SECTION 75W MODIFICATION APPLICATION LEE WHARF BUILDING C NEWCASTLE

MP 05_0007 (MOD 2)

Modification of Minister's Approval under section 75W
of the *Environmental Planning and Assessment Act*
1979

August 2010

WORK IN FIGURED DIMENSIONS IN PREFERENCE TO SCALE. CHECK DIMENSIONS ON DRAWING FOR VERIFICATION. THE DRAWING IS NOT TO BE USED FOR CONSTRUCTION OF WORKS WITHOUT THE EXPRESS PERMISSION OF EJE ARCHITECTURE.
DRAWN: BH
DATE: APRIL 2010
SCALE: 1:100
PROJECT No: 8402.1
PHASE: WD
DRAWING No: A01
REV: A

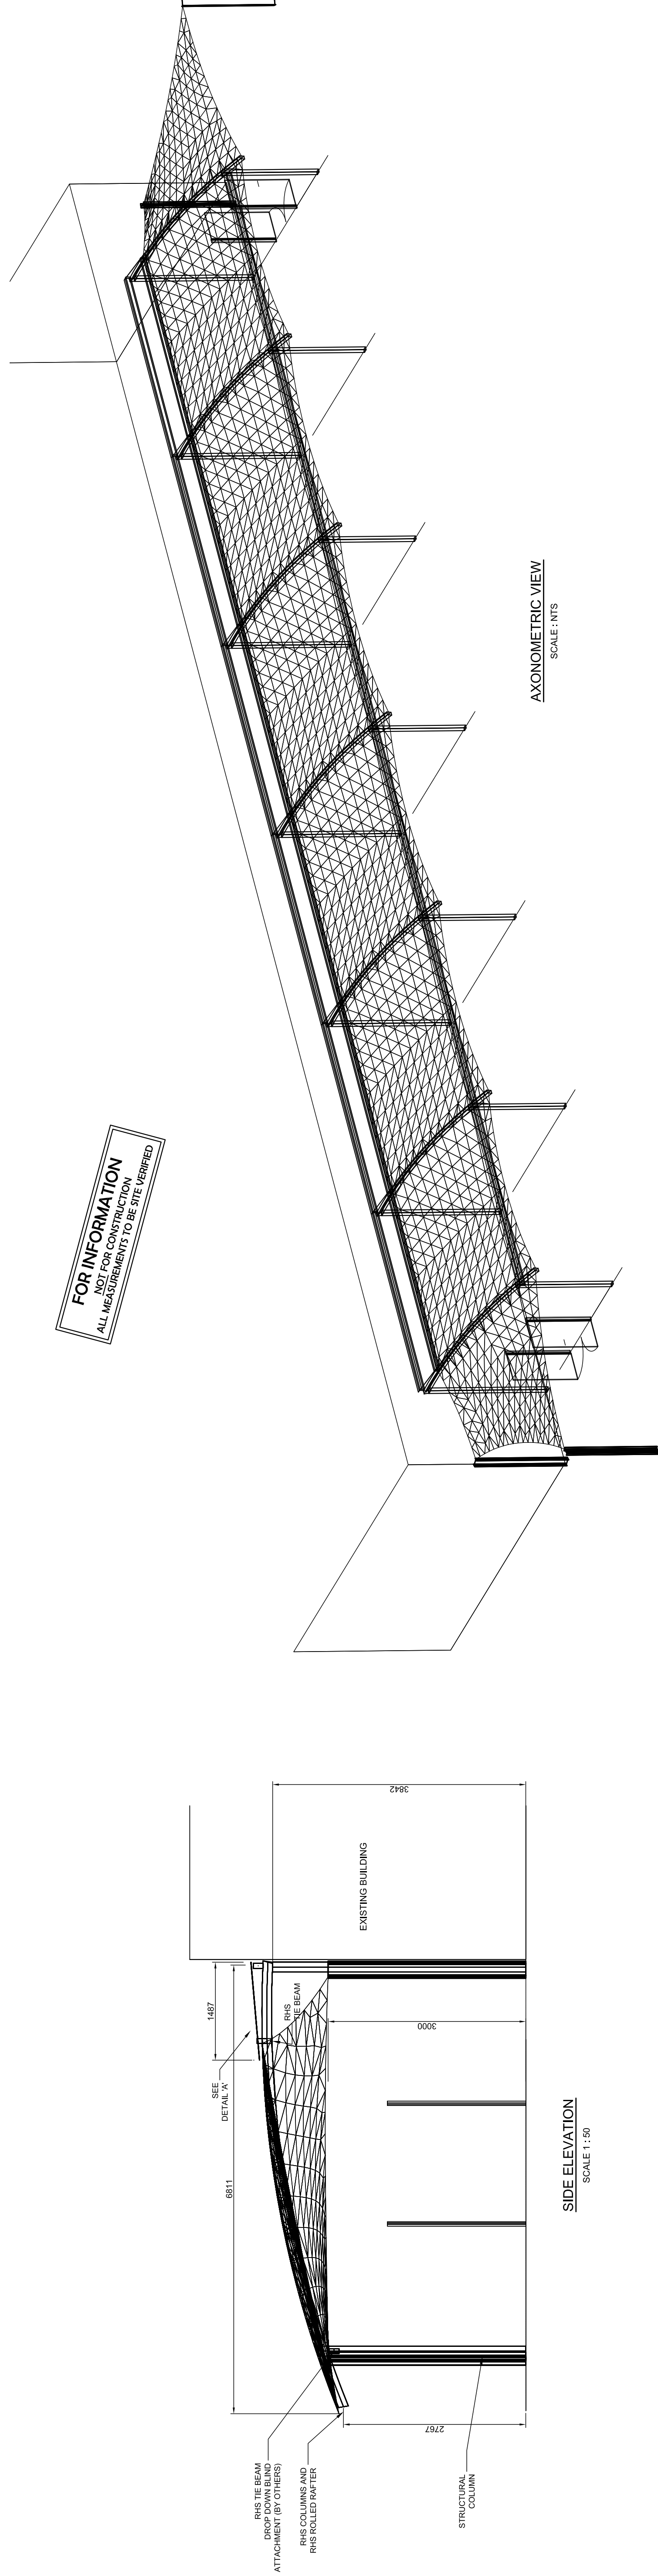
- The sail structure is separated from the building and this is desirable. Certification of the separation should be provided.
- Building is listed as having State Heritage Significance and should be referred to the Heritage Branch of the Department of Planning
- Sound walls should be verified that they will manage noise emissions.

Initially the Heritage Branch raised concerns about the size and scale of the proposal. However, after a site inspection was undertaken by the Branch on the 28 July 2010, the application was supported, subject to a condition being imposed to prevent the enclosure of the awning.

The approved plans illustrate the separation via a glass roof. Application was referred to the Heritage Branch. Sound walls do not form part of the application.

Agree. A condition will be imposed to ensure the awning is not enclosed.
